**Consultation Response from KC,
Conservation and Design**
2020/93954 Land at, Lingards Road, Slaithwaite, Huddersfield, HD7 5HY
Erection of 57 dwellings and associated works
Date Responded: 08.01.21
Responding Officer: NG
Responding Ref: CV13/249/250
Context

| 2019-572-11 G                                                                                                         |          |            |  |

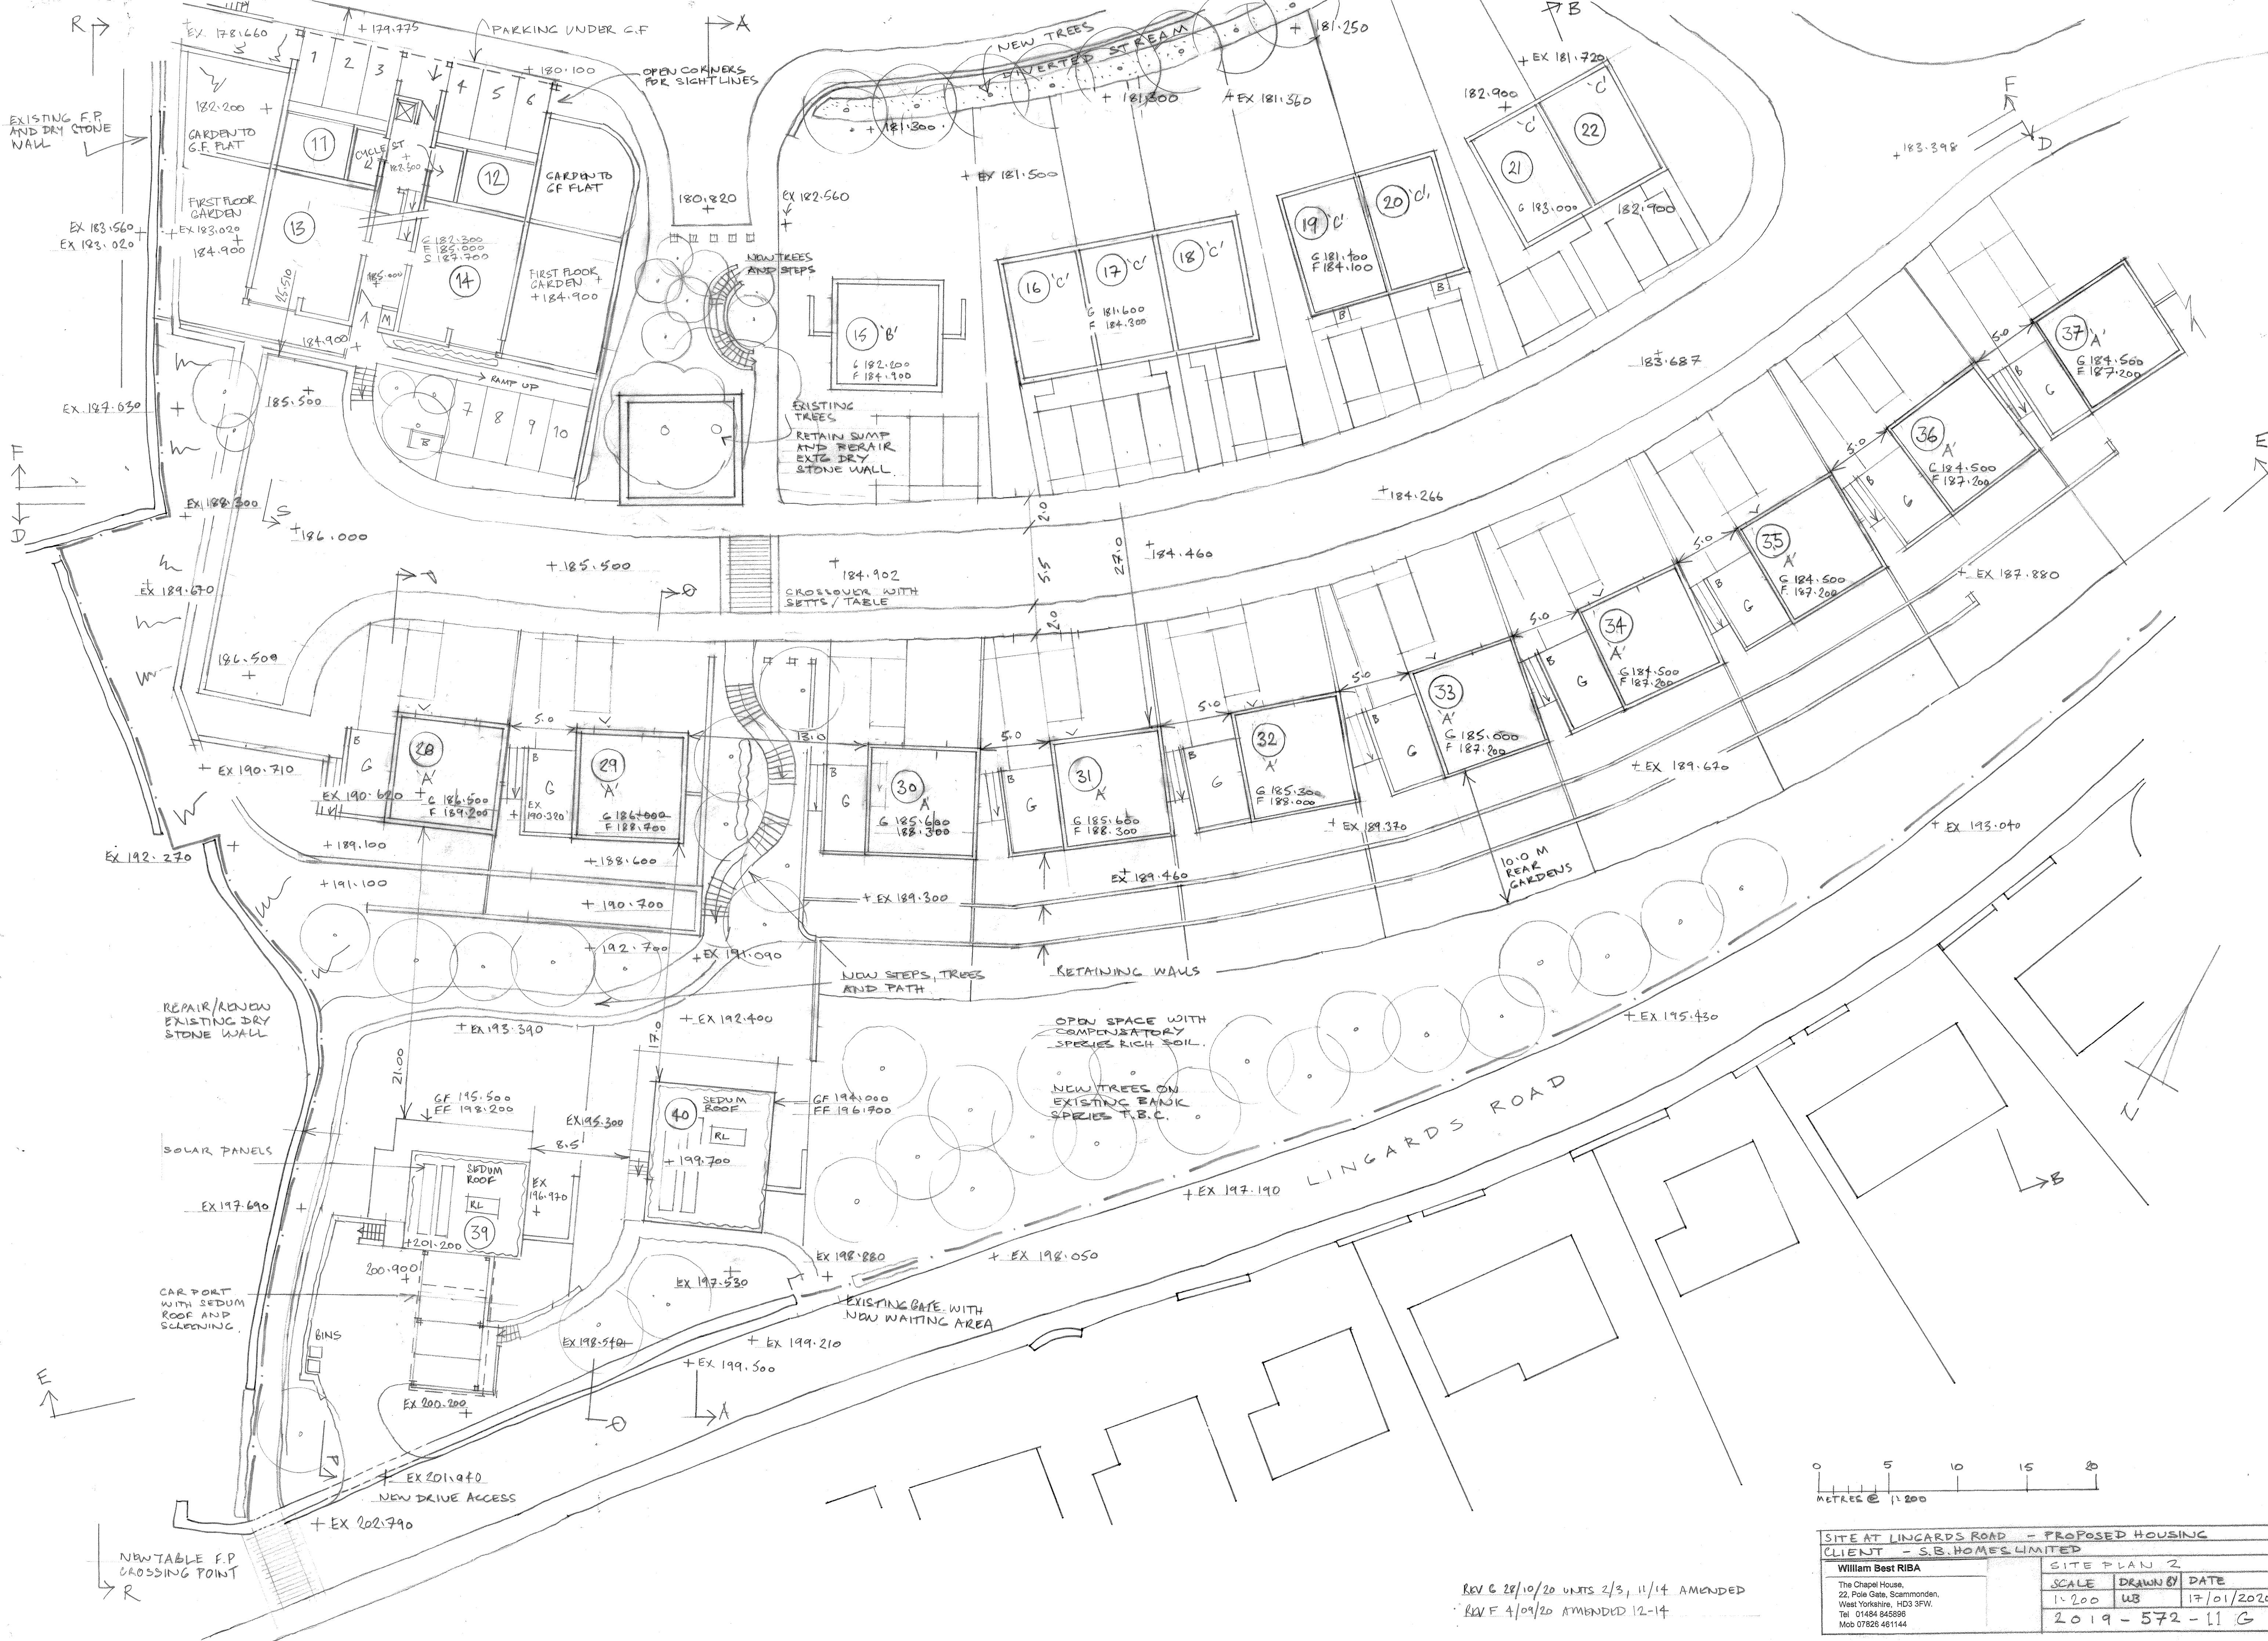
The number of units means that the development is reliant upon extensive engineering works to maintain the hillside slopes and results in an island of unmanaged, open-space on the steeper sections flanking Lingards Road. This would be enclosed by the rear gardens and fencing of units 28 to 38 and would read as simply space left over after development rather than integrated amenity or green space. The proposal also fails to provide any consideration of the direct or indirect impact on the heritage assets. The setting of the listed buildings would be compromised by the encroachment of a cul-de-sac of smaller units of Road 2, with the proposed flat units tightly enclosing their boundaries.

SITE PLAN 1	
SCALE	DRAWN BY DATE
1:200	WB 17/01/2020
2019-572-10 G

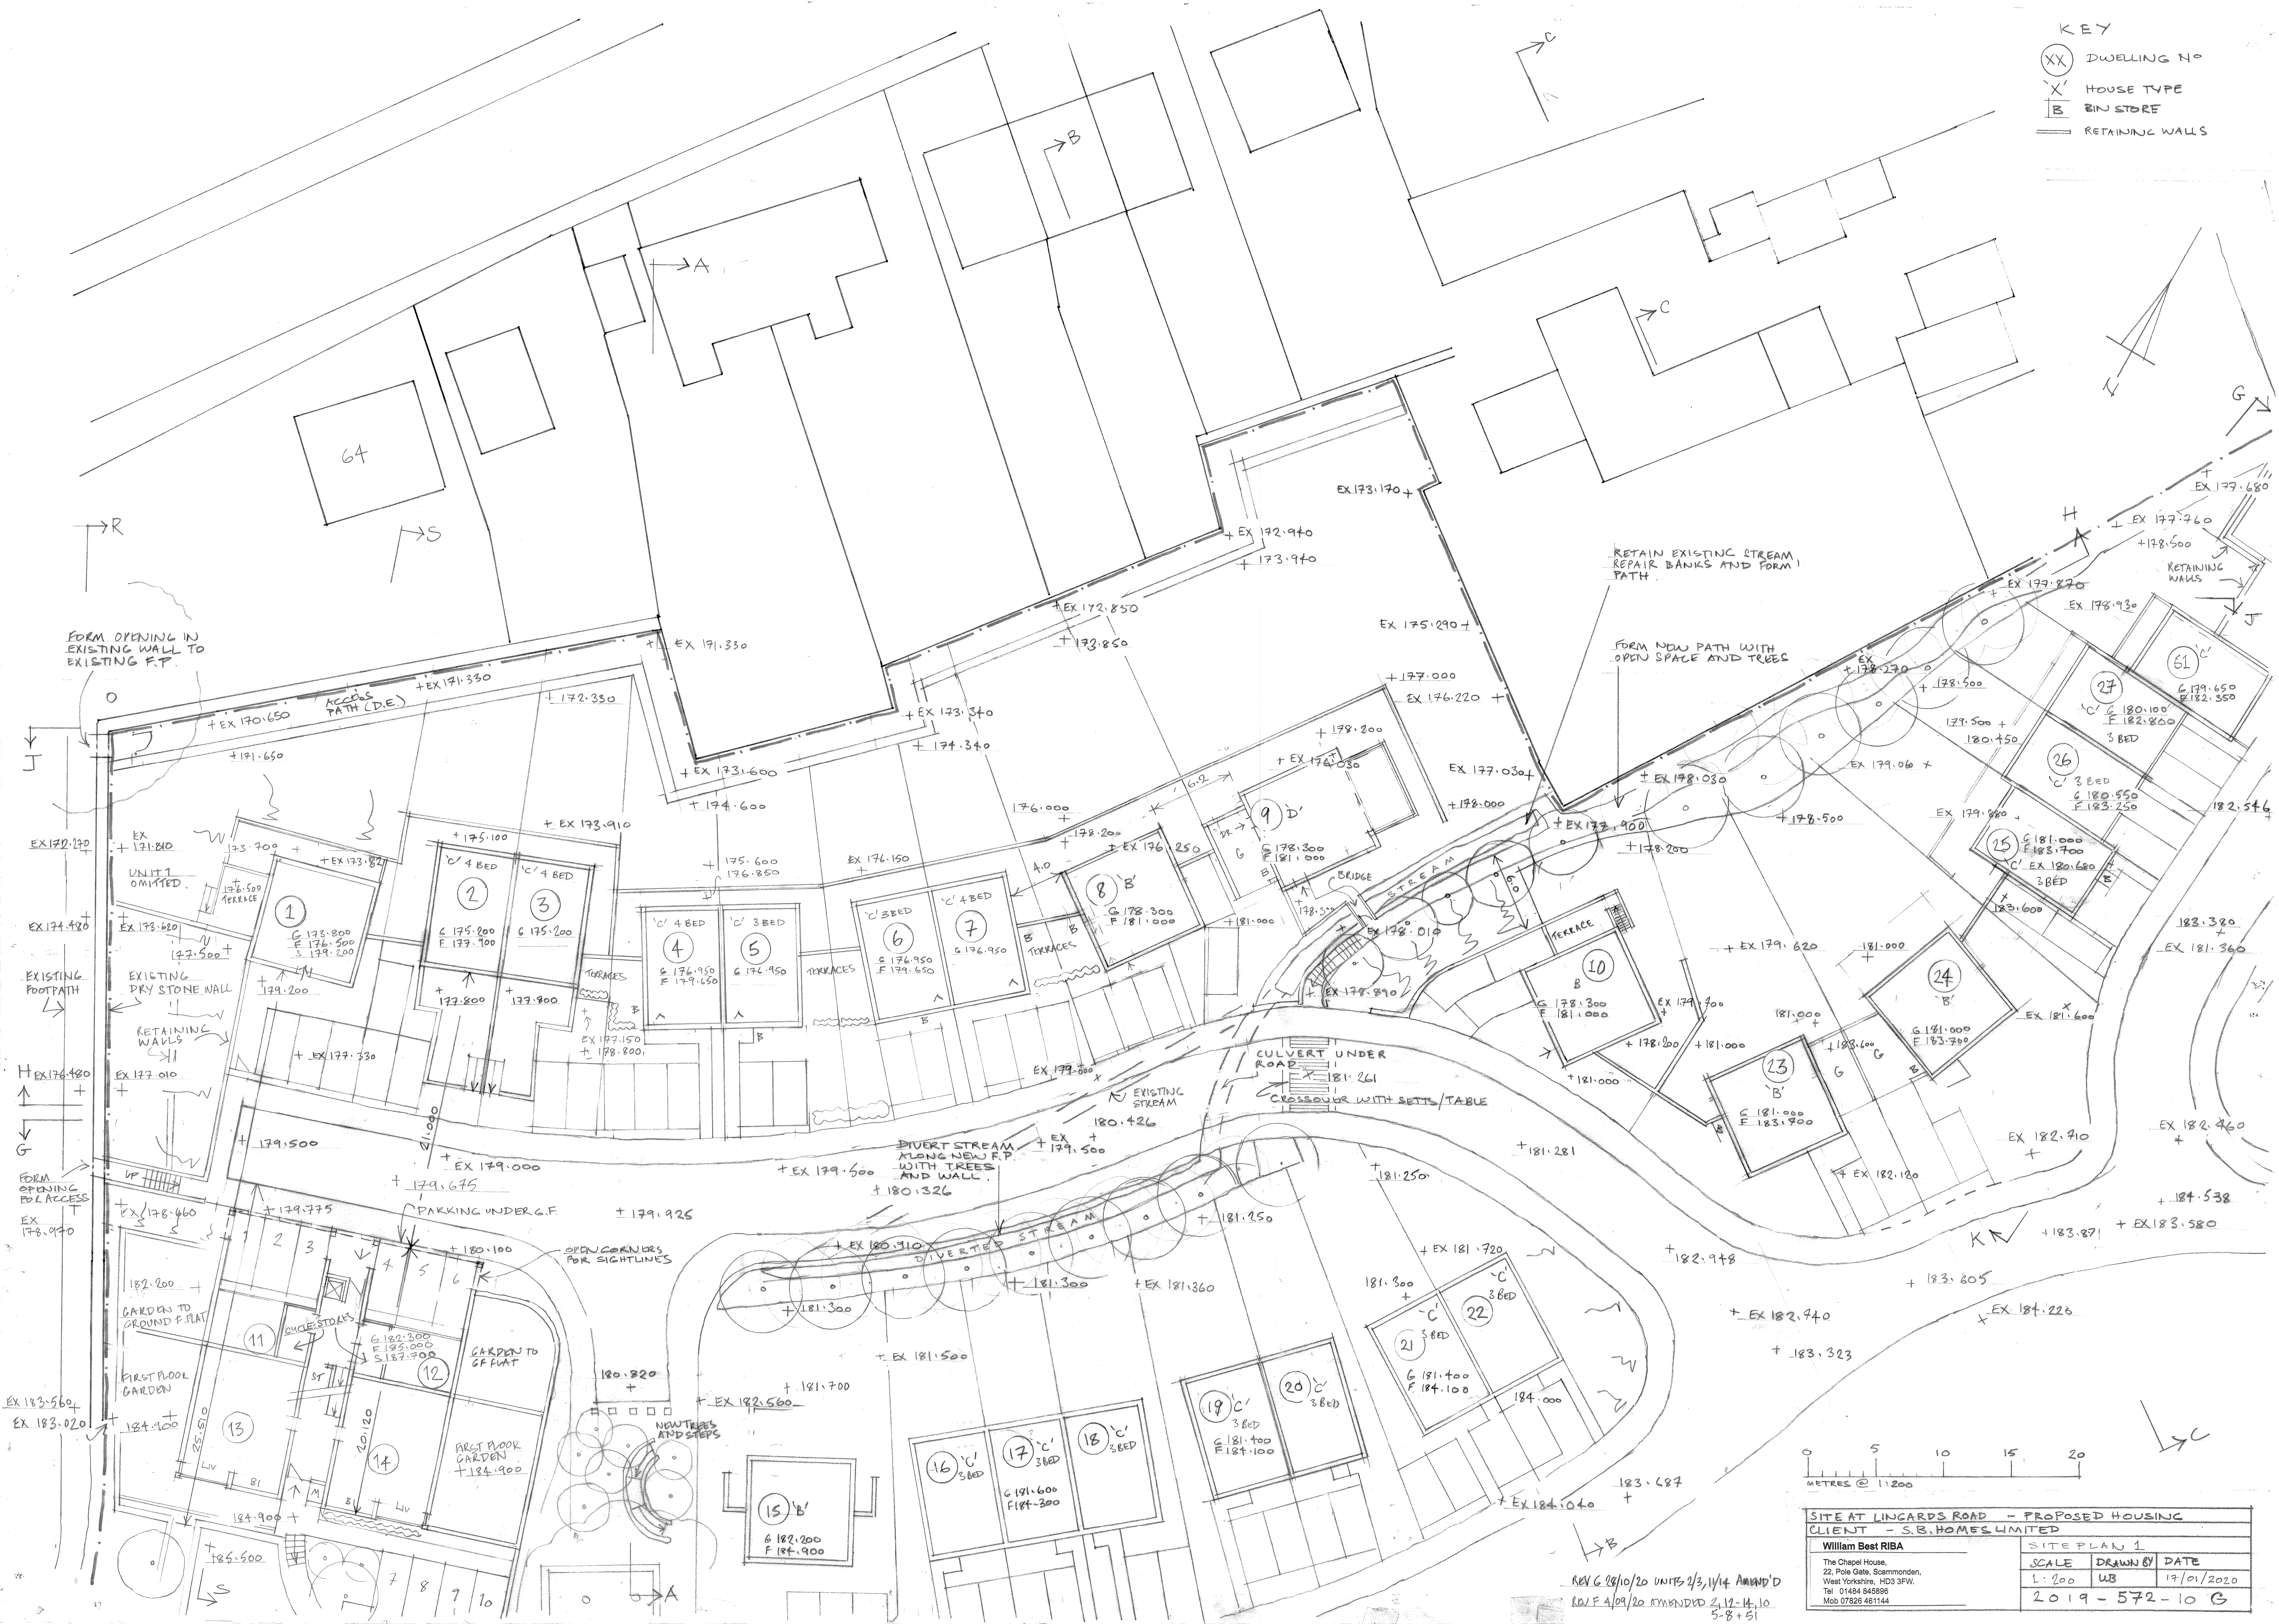
The proposed layout is characterised by extensive areas of hard-standing surfaces and vehicle parking and appears to be simply focused on the accommodation of the maximum (excessive) number of units and vehicle movement across and along the contours of the site. The proposed residential units are tightly packed with minimum amenity space, no accessible green space, no provision for streetscape planting and insufficient accommodation for the movement of biodiversity.
